Appendix A – Response to DPHI RFI

Table 1 Response to matters raised by Department of Planning, Housing and Infrastructure (DPHI)

Drawing Name
ENVELOPE CONCEPT
SSDA - ELEVATION

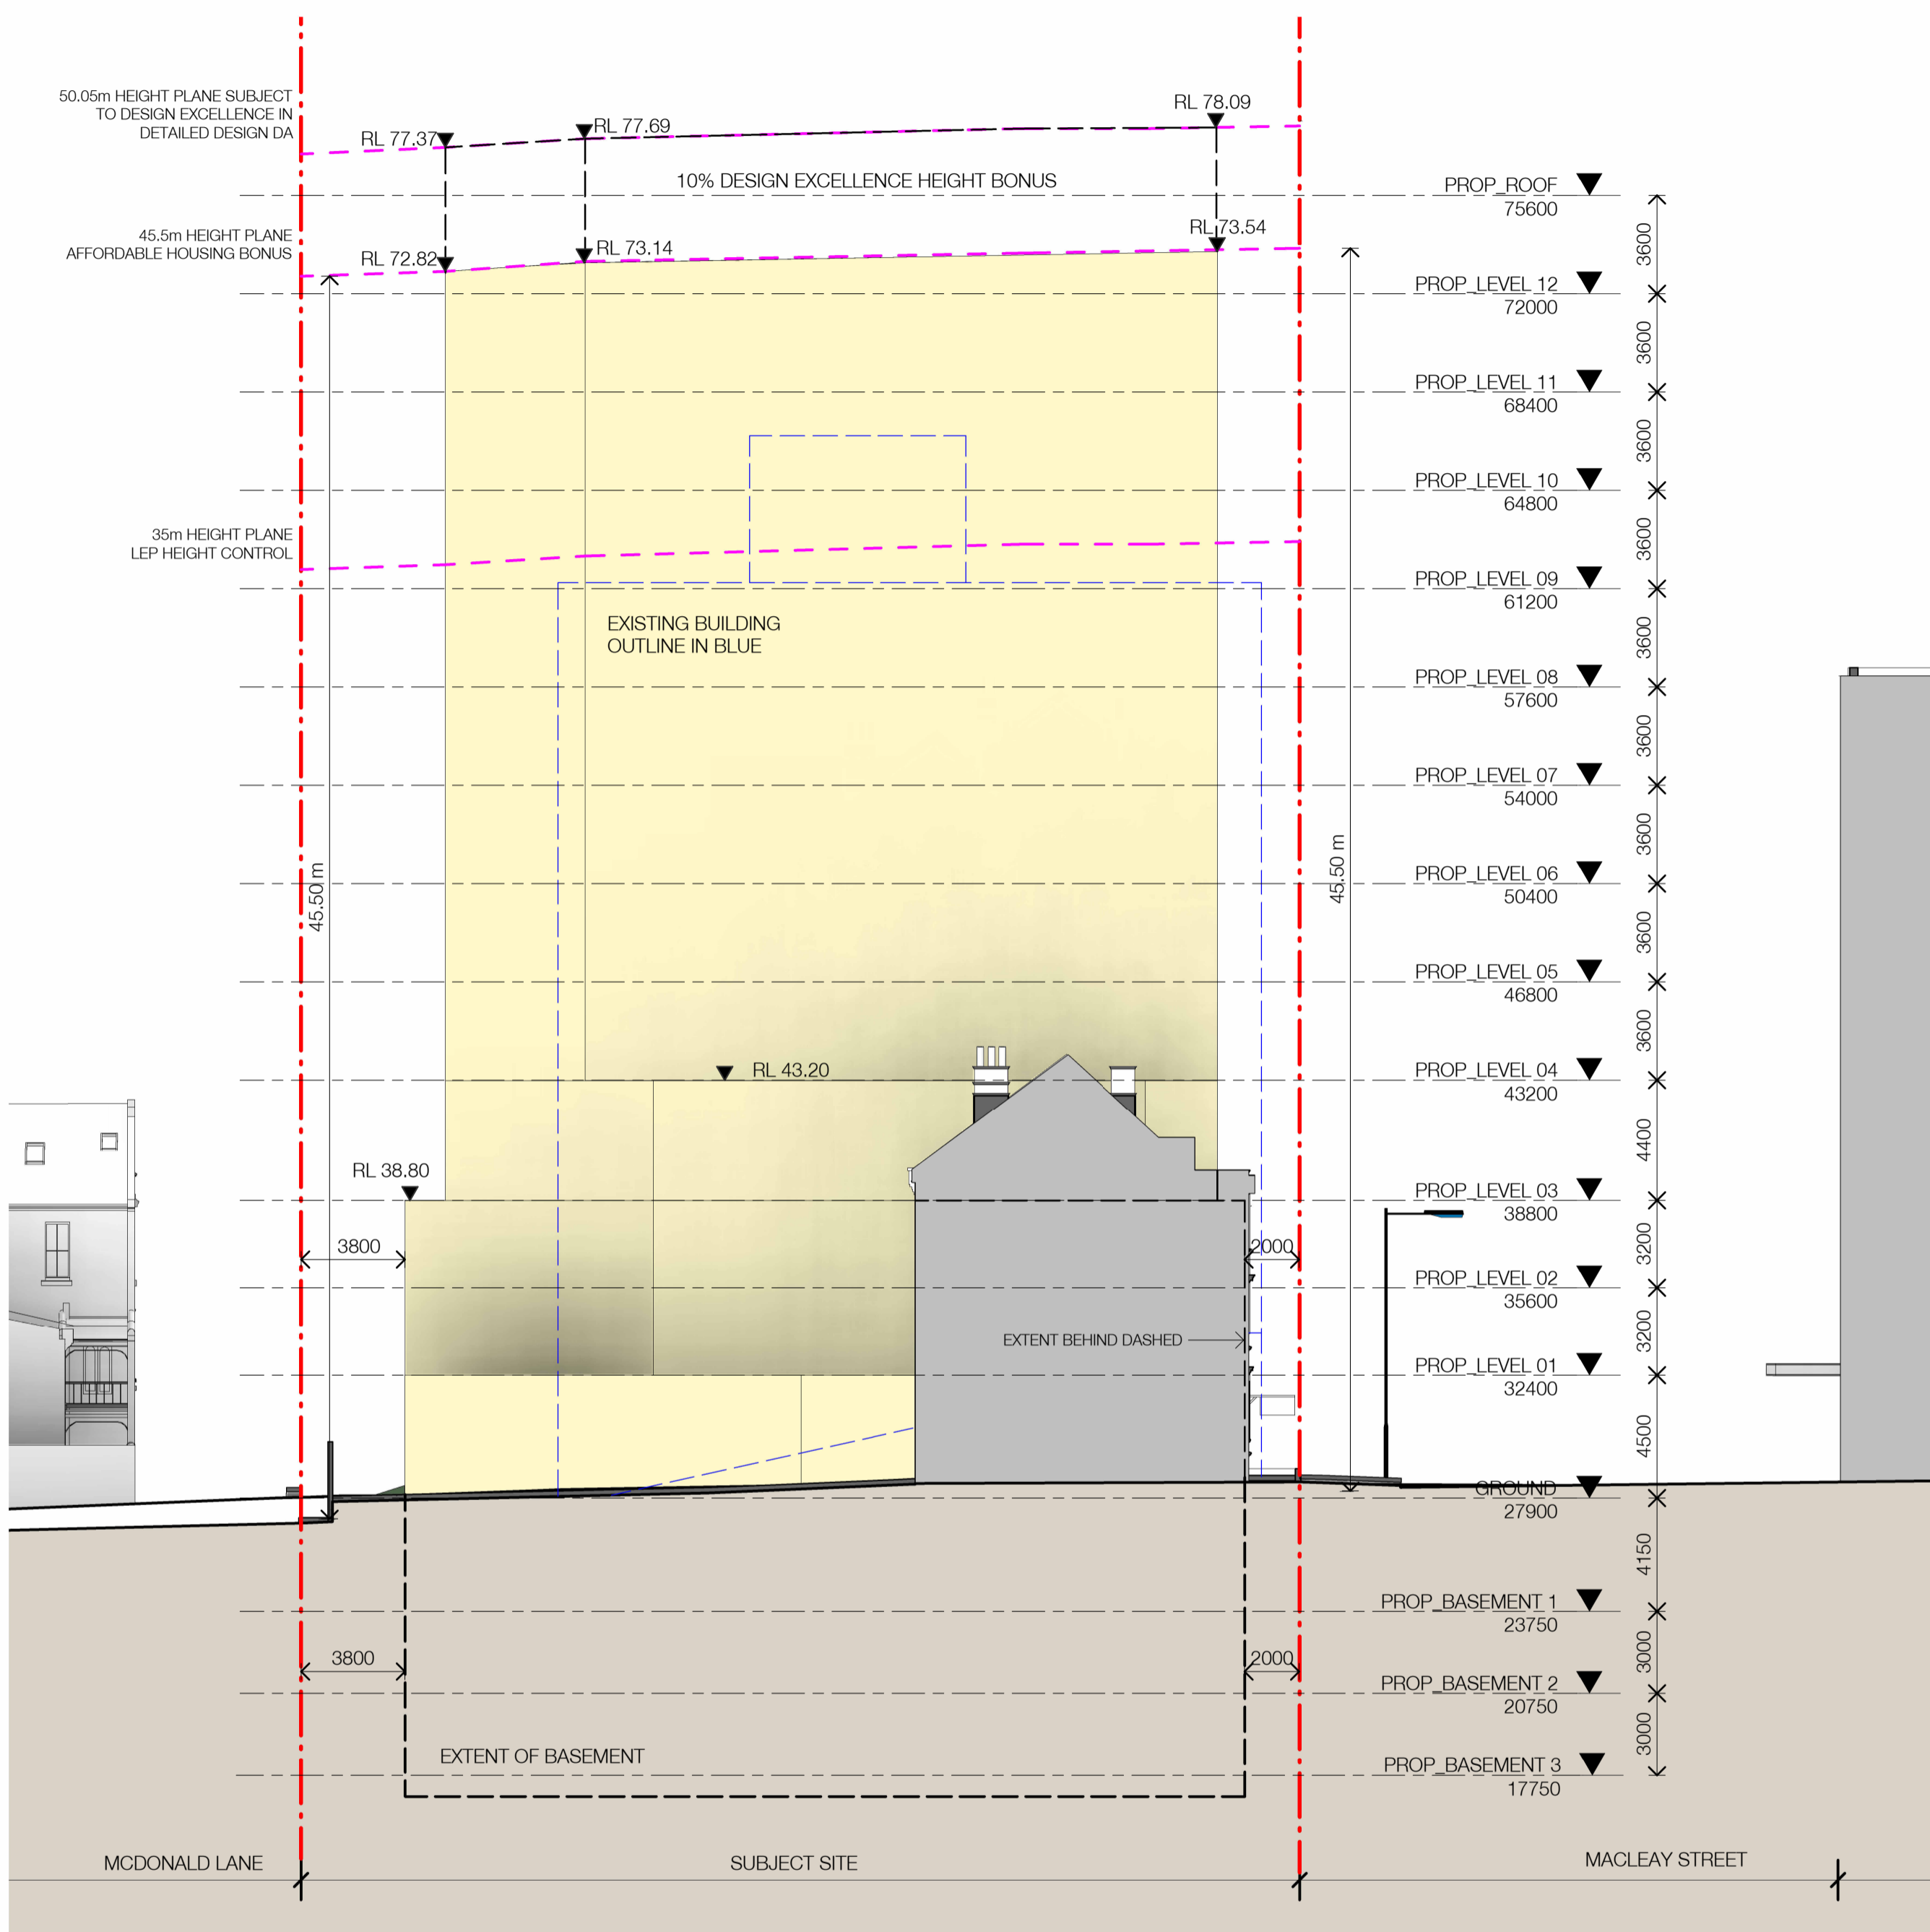
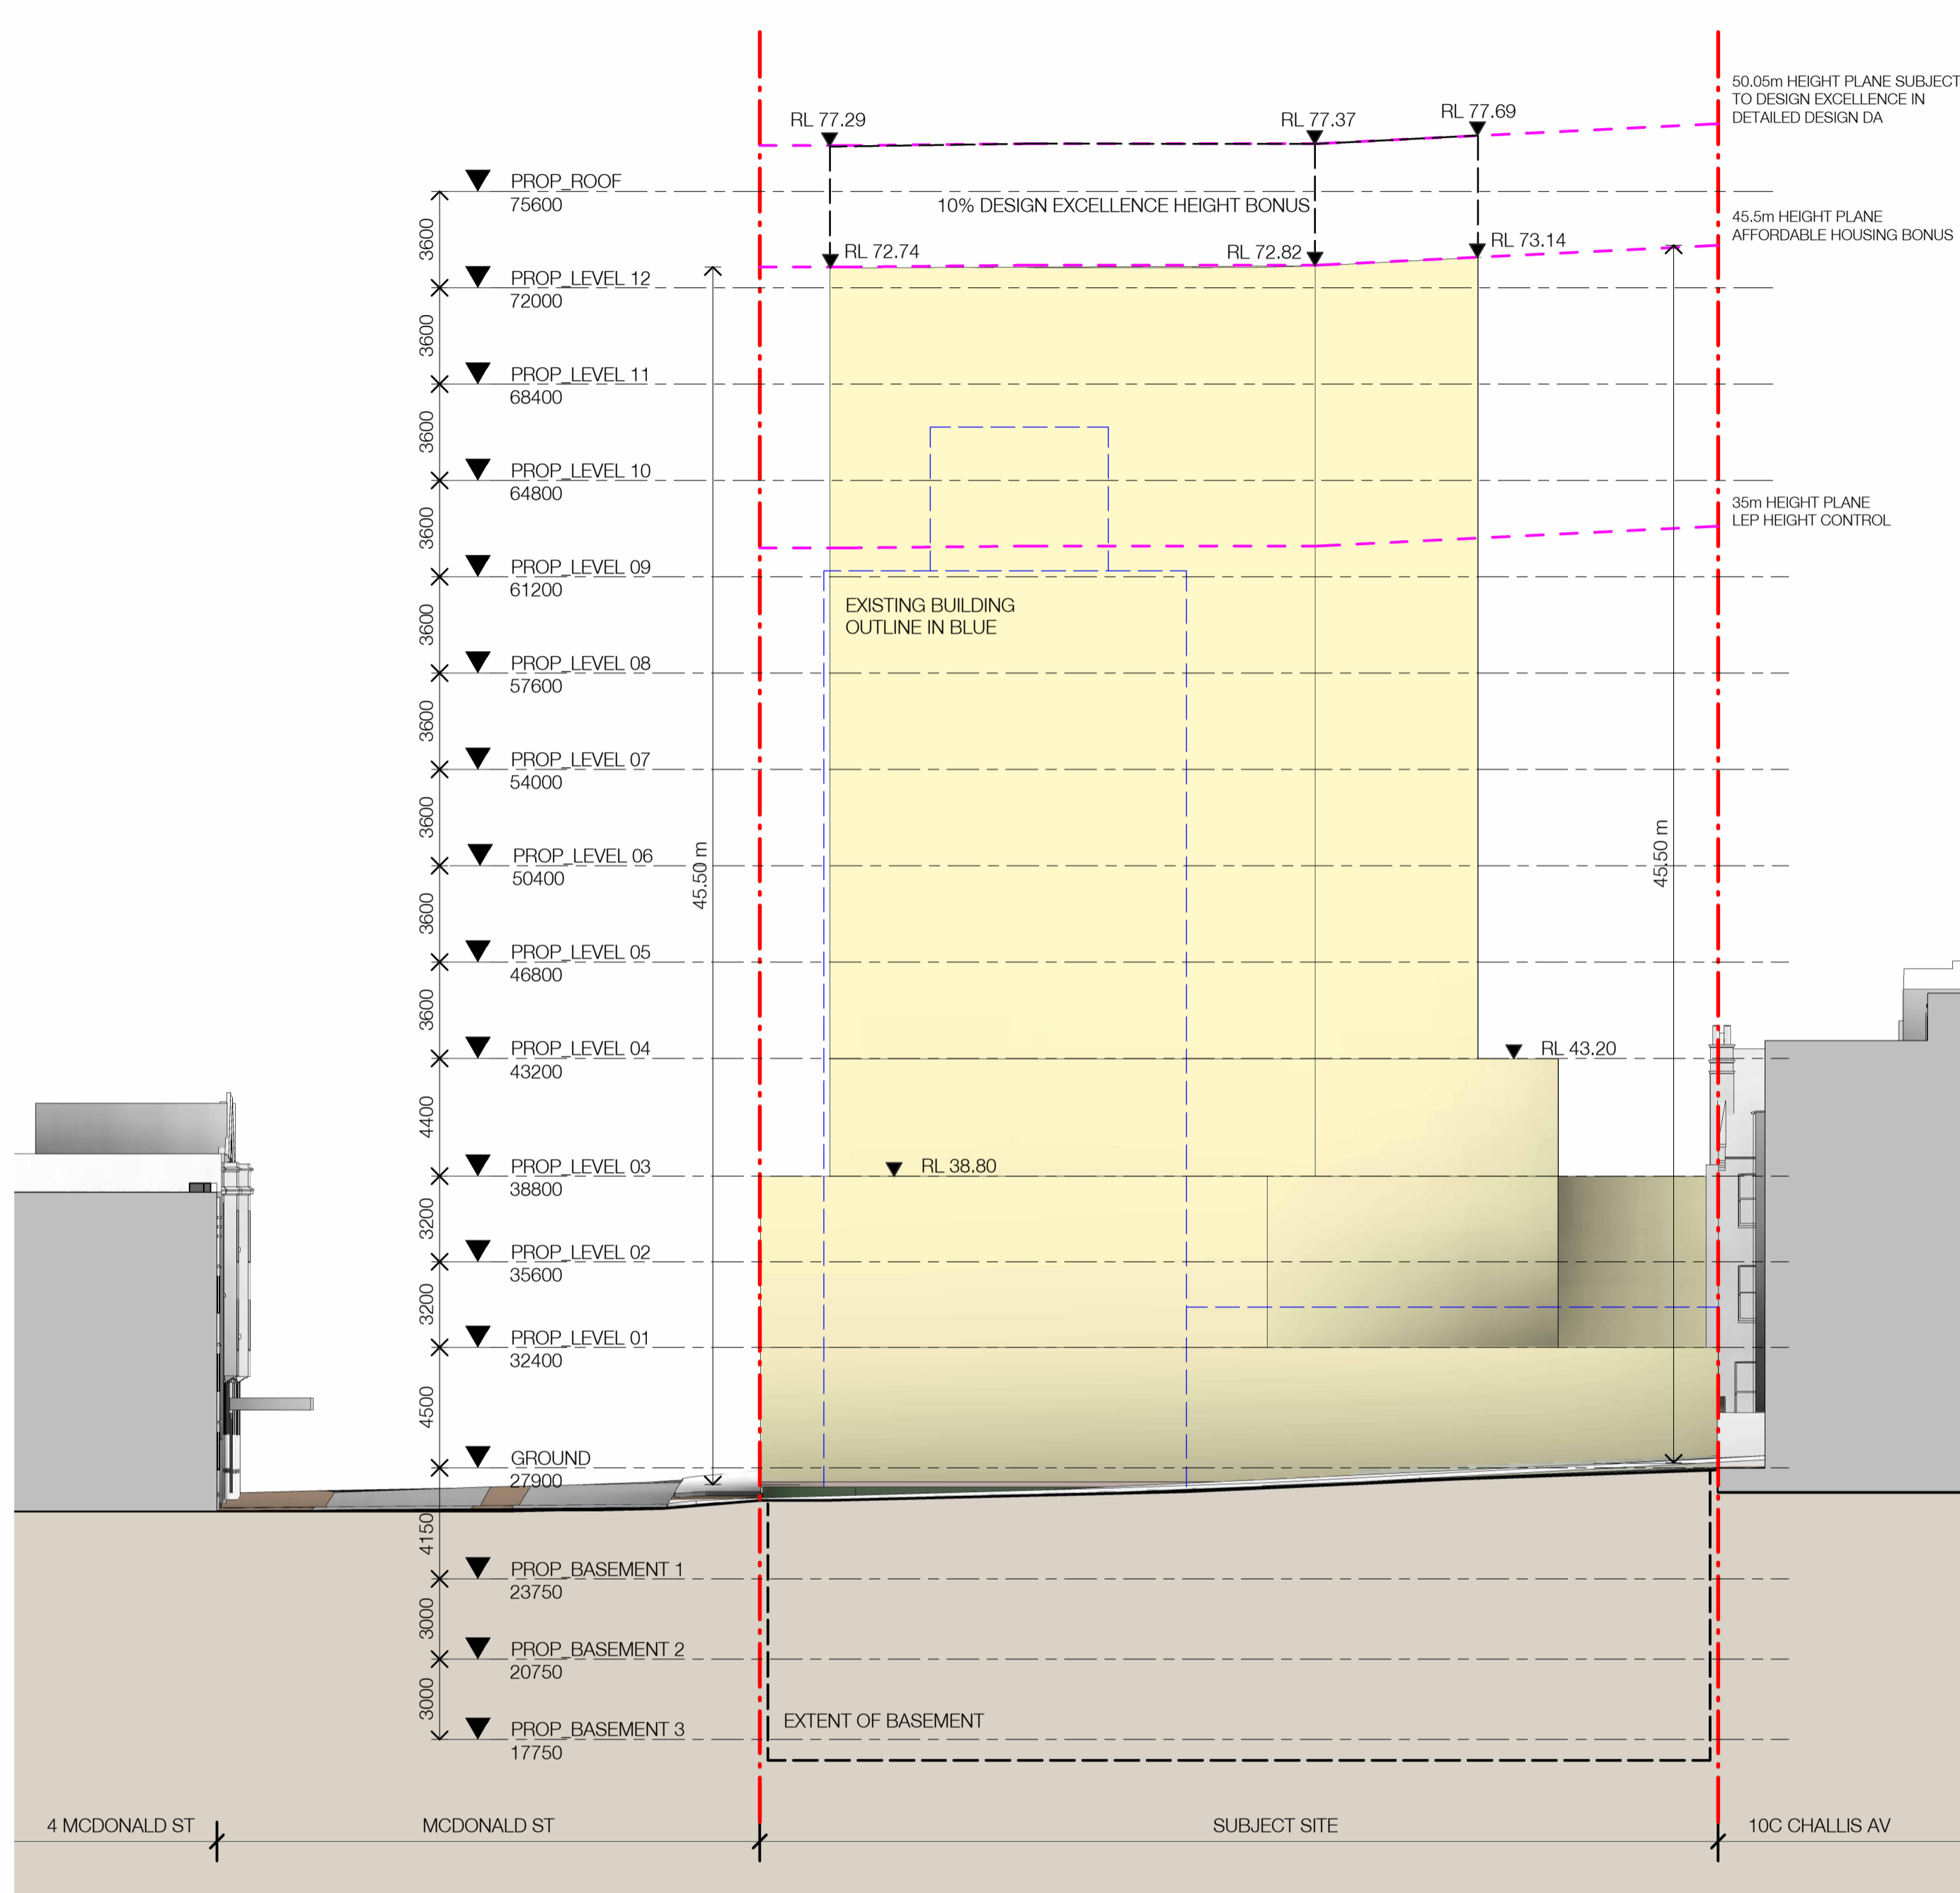
(b) Indicate the location and area of deep soil zones on the site plan.	The deep soil zone is proposed to be located along McDonald Lane and has been depicted in the updated Site Plan at Appendix B.	Appendix B
(c) Align the basement setbacks between the site plans and elevations. Specifically, the 2m eastern setback and the 3.8m western setback to the basement depicted on the site plan are not accurately depicted on the elevations.	The envelope elevation plans have been updated to show the basement setbacks at Appendix B.	Appendix B
(d) Detail the street names/frontages on the height plan diagrams.	Amended height plane diagrams containing street names have been provided at Appendix B.	Appendix B
